City of Albuquerque

May 13, 1994

RE: DRAINAGE PLAN FOR AN ADDITION TO 708 MARQUETTE NW (J14-D106)
ENGINEER'S STAMP DATED 4/13/94.

Figure 2 - Developed Site Plan (Plate 3)

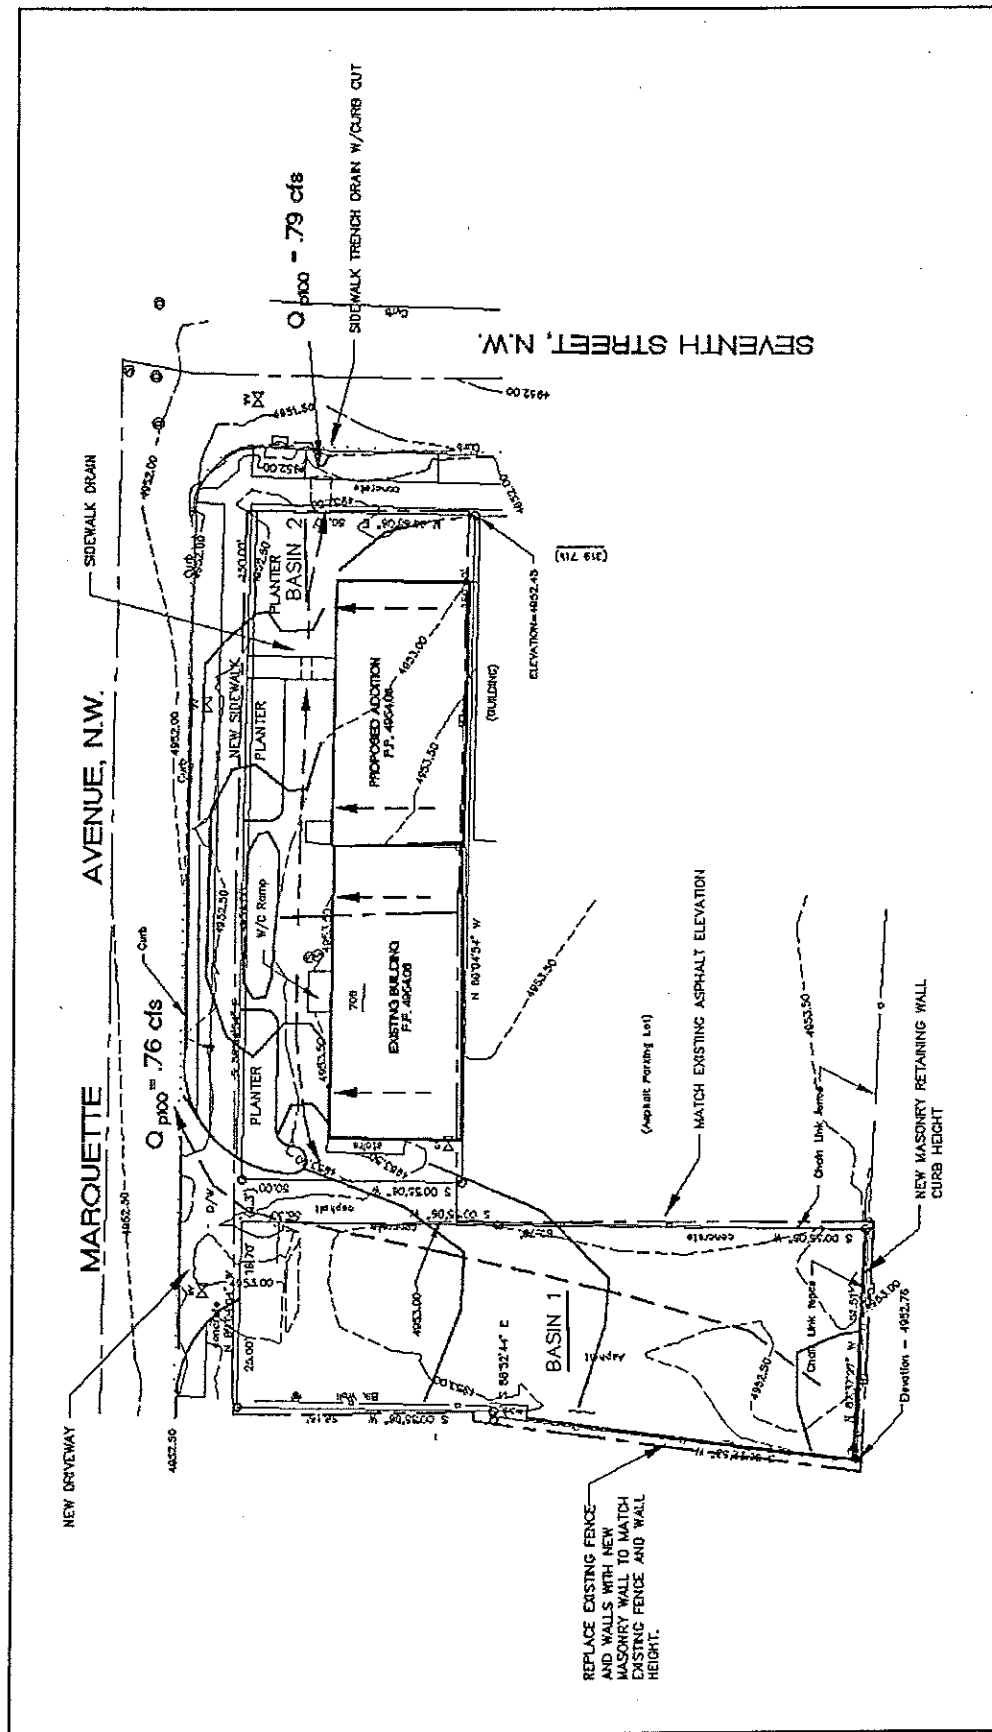
2. top of curb and flowline elevations on Marquette & Seventh St.
3. Your report identifies that you have a total of .689 cfs existing and .634 cfs proposed flow rates. The plan drawing indicates .76 cfs from basin 1 & .79 cfs from basin 2. I am confused to the difference in the quantities. Pre-design indicates that you are limited to the existing flow rate.
